# Mining & Petroleum Gateway Panel

**Report by the Mining & Petroleum Gateway Panel to  
accompany a Conditional Gateway Certificate for the West  
Muswellbrook Project**

**May 2015**

Figure 3-5 Verified-BSAL within the PAA (northern extent, scale 1:25,000) (adapted from Richards, 2014)

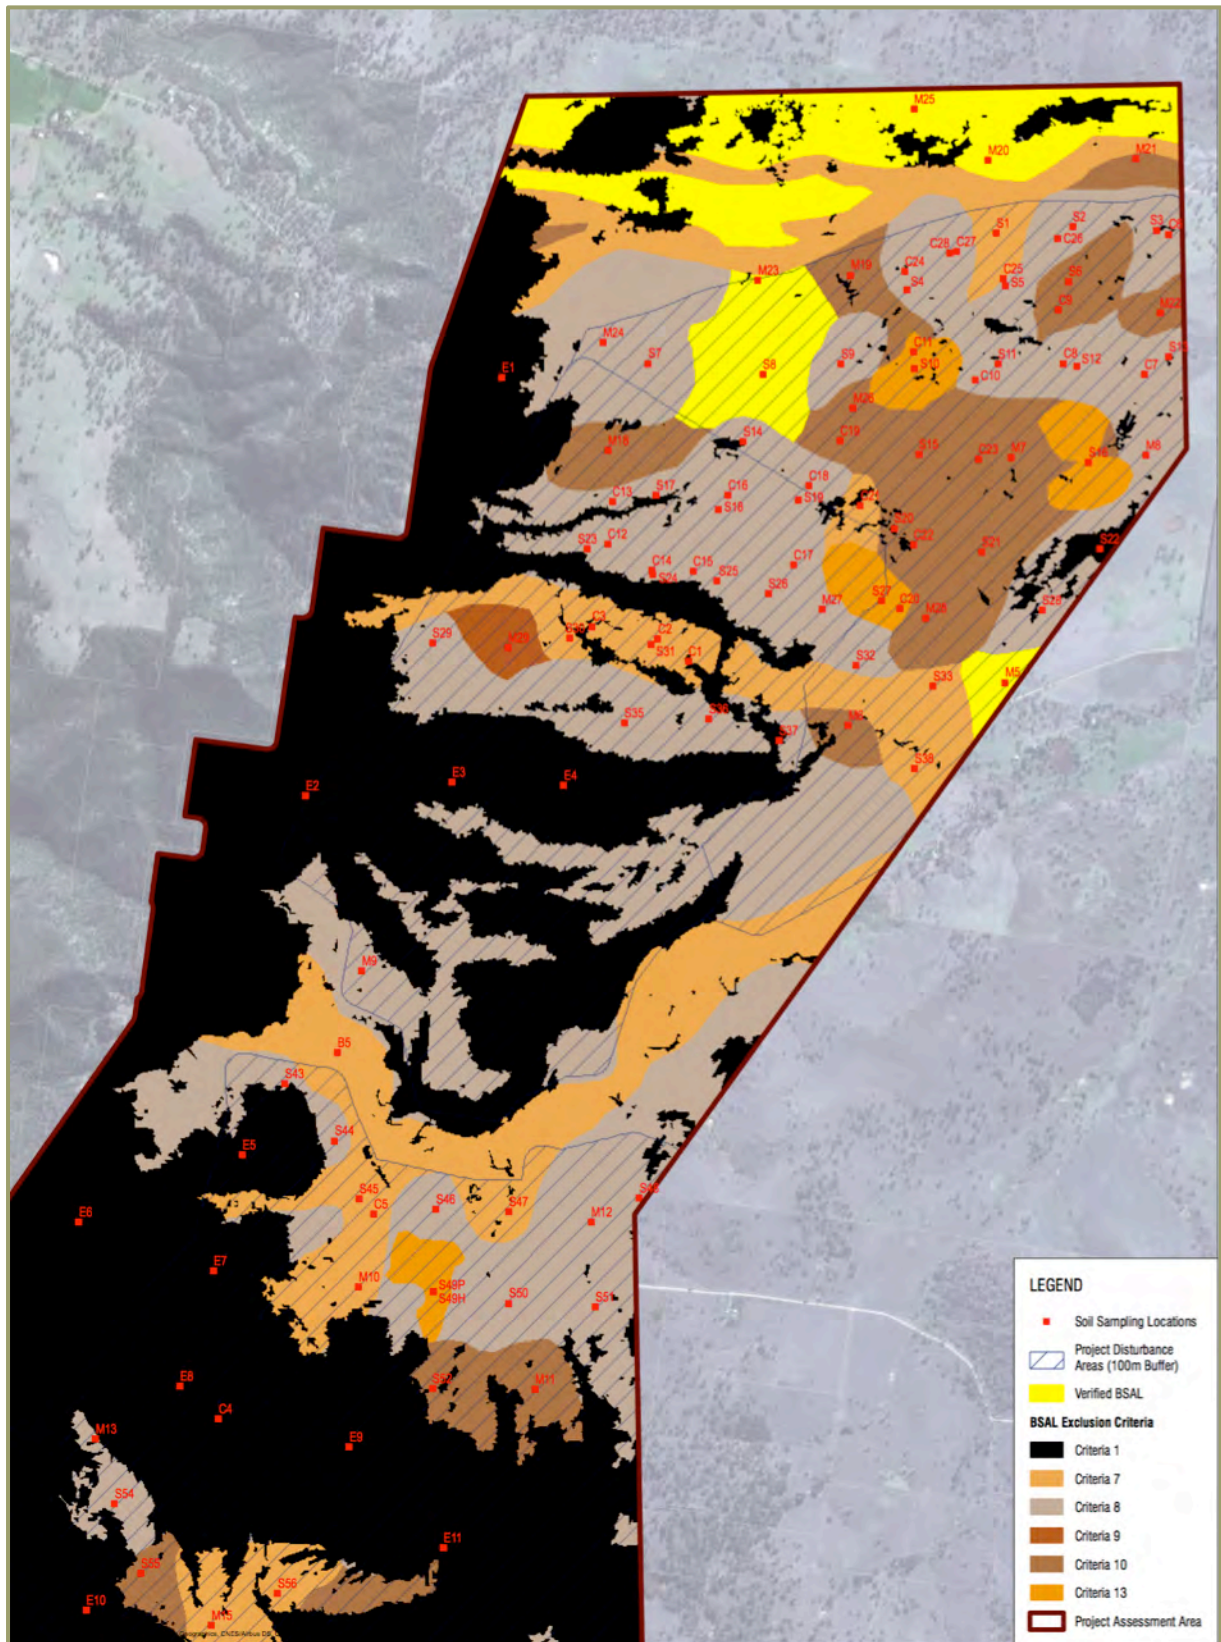
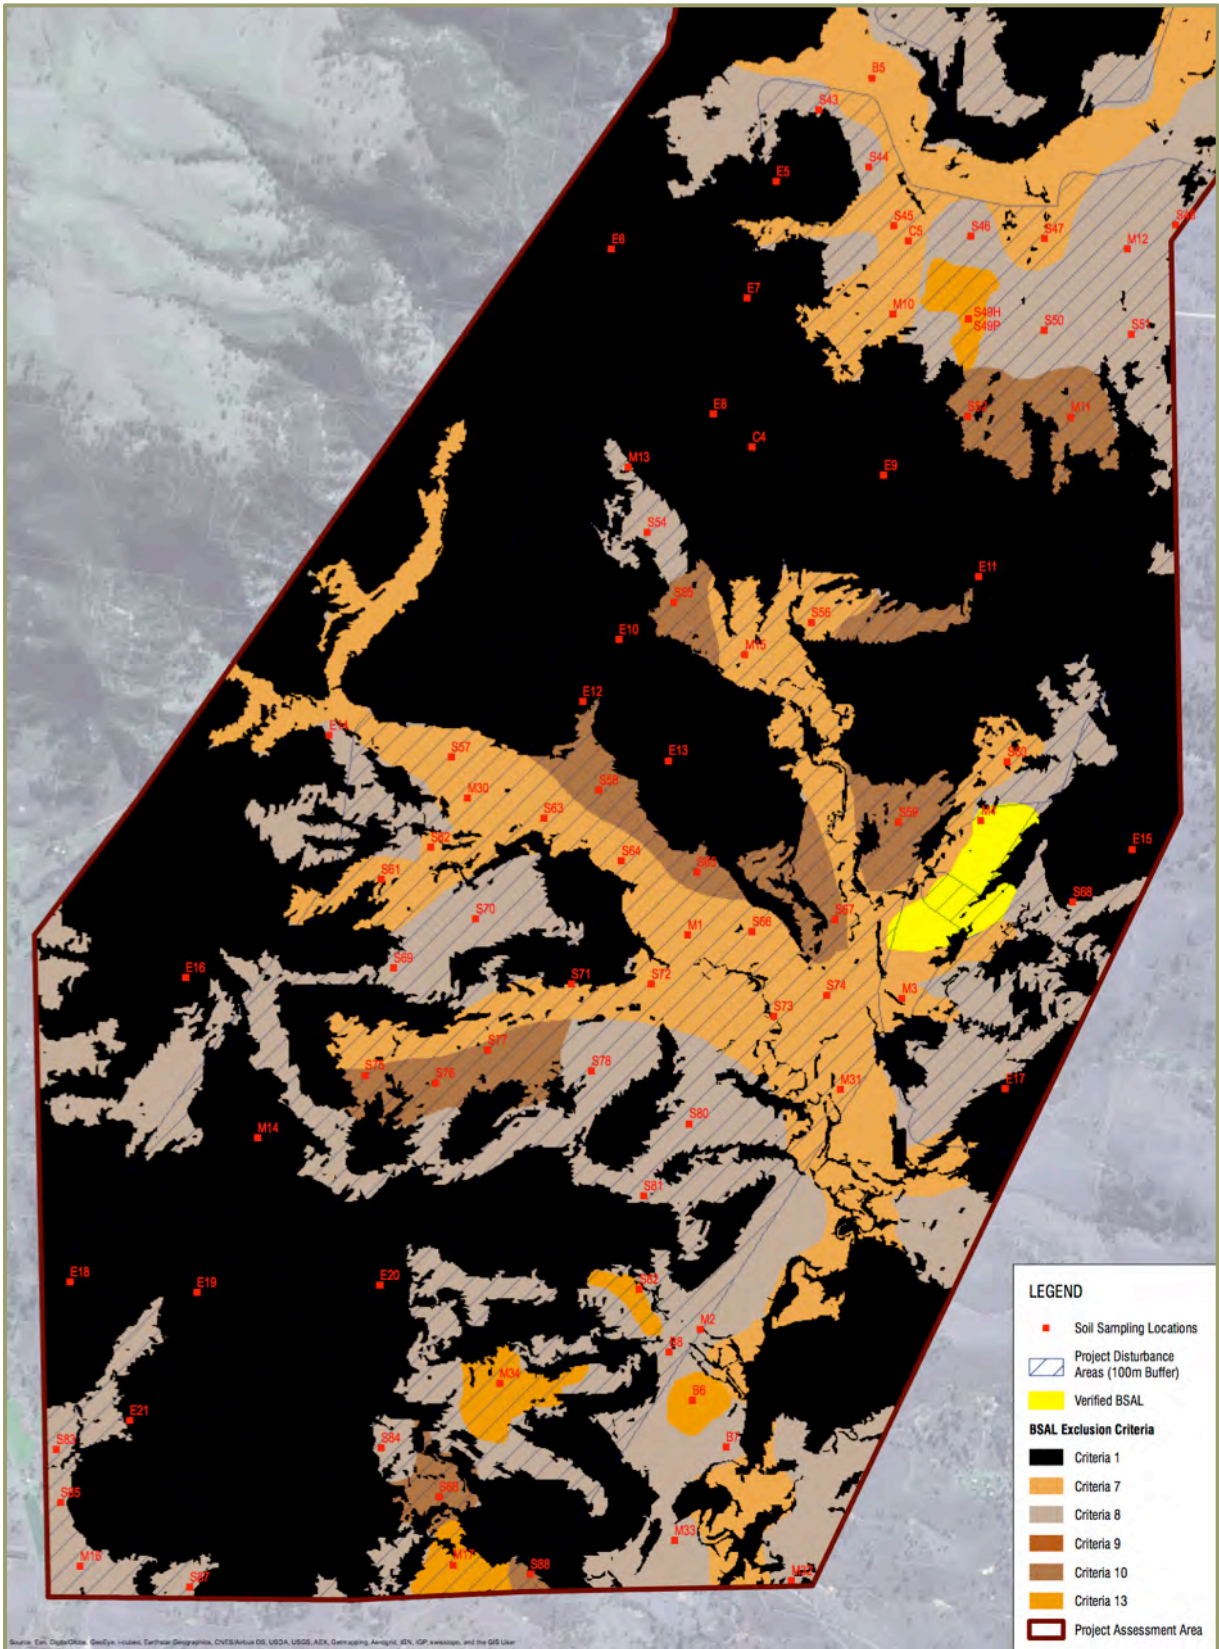
- The less than 20 ha extent criteria used to exclude site M34 is located on the South Eastern periphery of the PAA should be reviewed to determine whether there is contiguous BSAL land directly outside the PAA that might lead to the >20 ha criteria being satisfied.
- The chemical analysis used to determine that sites M2, M32 and M33 are not BSAL have been correctly adjusted for bulk density and saturation in the calculation of the salinity and chemical toxicity of these soils.

The Proponent through a soil survey and chemical analysis methodology has identified that the PAA contains 204.6 ha of verified BSAL (Figure 4a & Figure b) Much of this verified (136.2ha) BSAL lies in the Northern part of the Project area adjacent to Rossgole Road and is outside of the disturbance area (Figure 4a). The majority of the verified BSAL is located on Land and Soil Capability Class 2 and 3 indicating that it is capable of a wide variety of land uses (cropping, grazing, horticulture, forestry, nature conservation).

Figure 4-1 Conceptual mine layout design, and verified BSAL and CIC lands

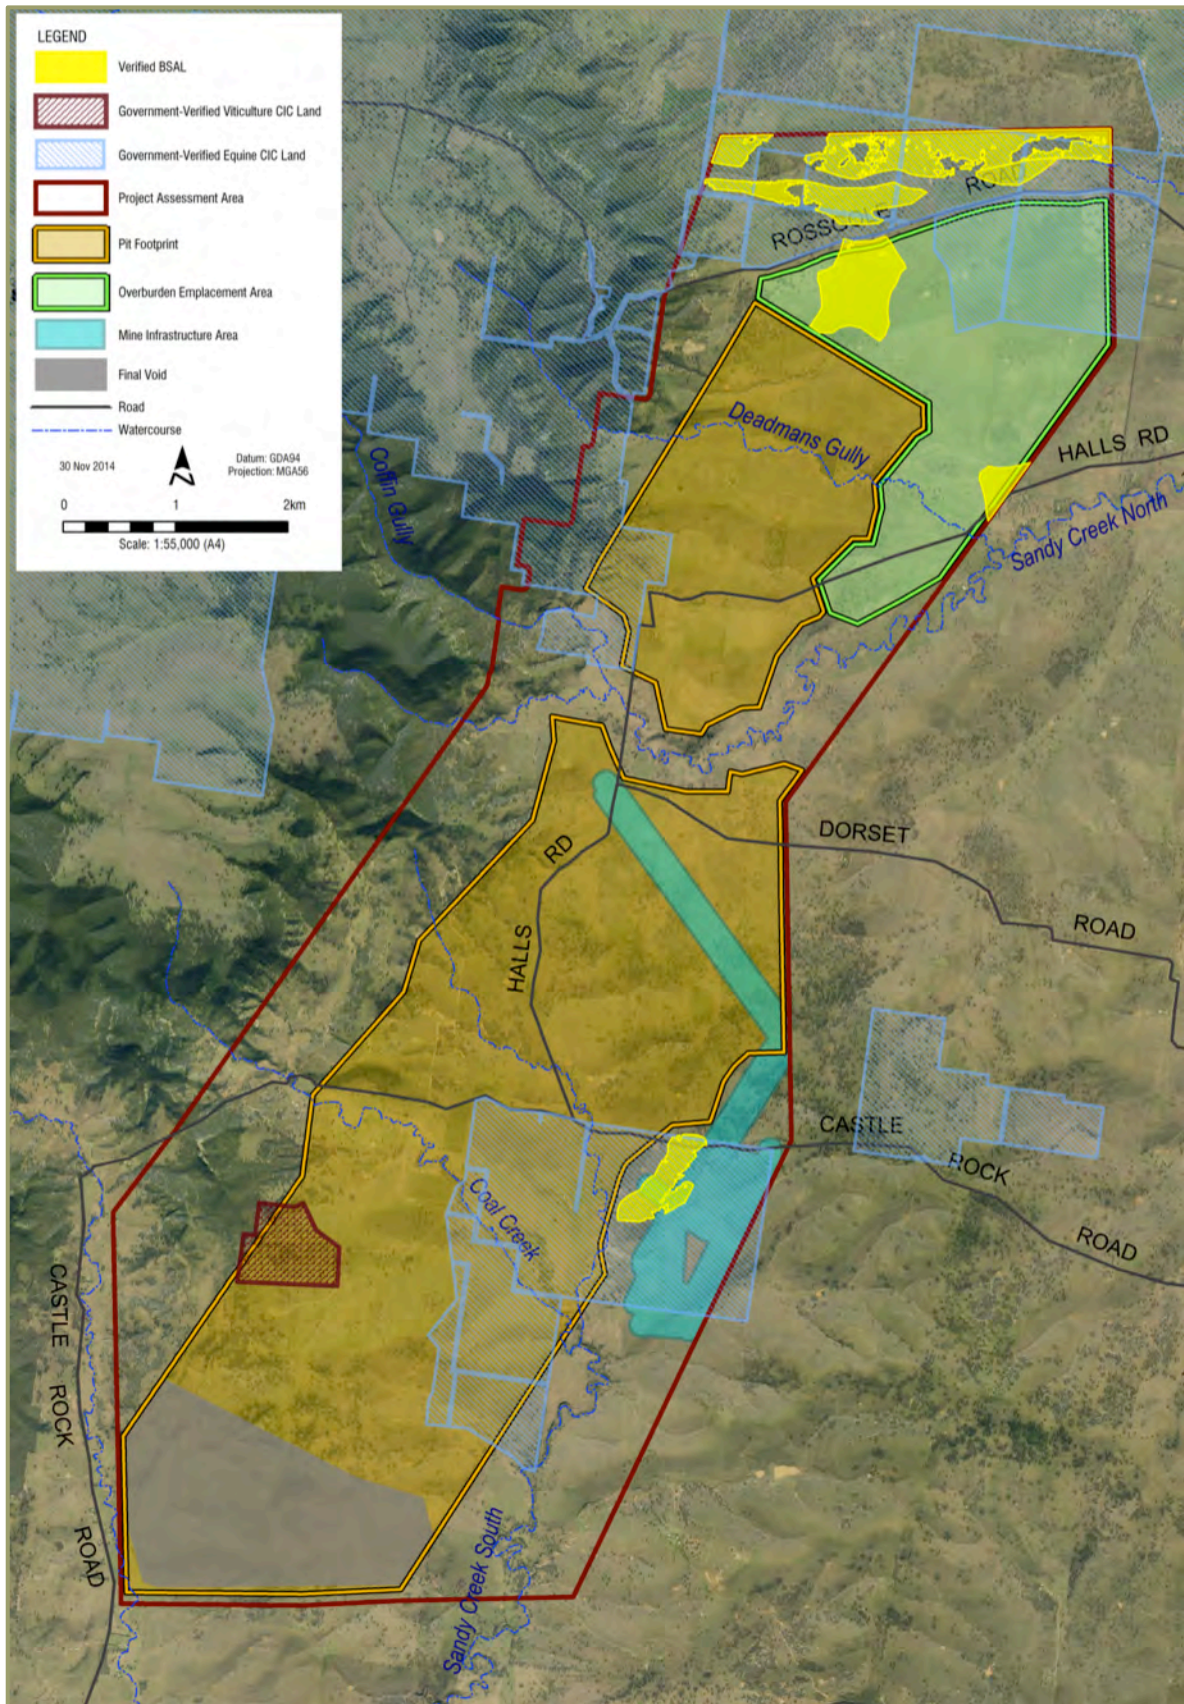
The Project will cause significant direct impacts to verified BSAL, mapped equine CIC land and mapped viticulture CIC land within the Project Boundary as follows:

1. For verified BSAL: 68.4 ha will be permanently lost in mining operations and therefore directly impacted as a result of open cut mining activities.
2. For Government verified equine CIC land: open pit mining and associated activities will have direct and significant impact on 704.5 ha of verified equine CIC land mine. Post rehabilitation the Project will result in the permanent loss of 577 ha of verified equine CIC land.

The Proponent refers to the “temporary” impact of 127.6 ha of verified equine CIC (included in the total of 704.5 above). However, the report provides no further mention of rehabilitation of this CIC land. It is recommended that where rehabilitation of CIC land is planned and accounted

for in totals of mining disturbance areas that further clarification and details of rehabilitation should be provided.

3. For Government verified viticulture CIC land, open pit mining activities will have direct and significant impact on 49.5 ha resulting in the permanent loss of this land.
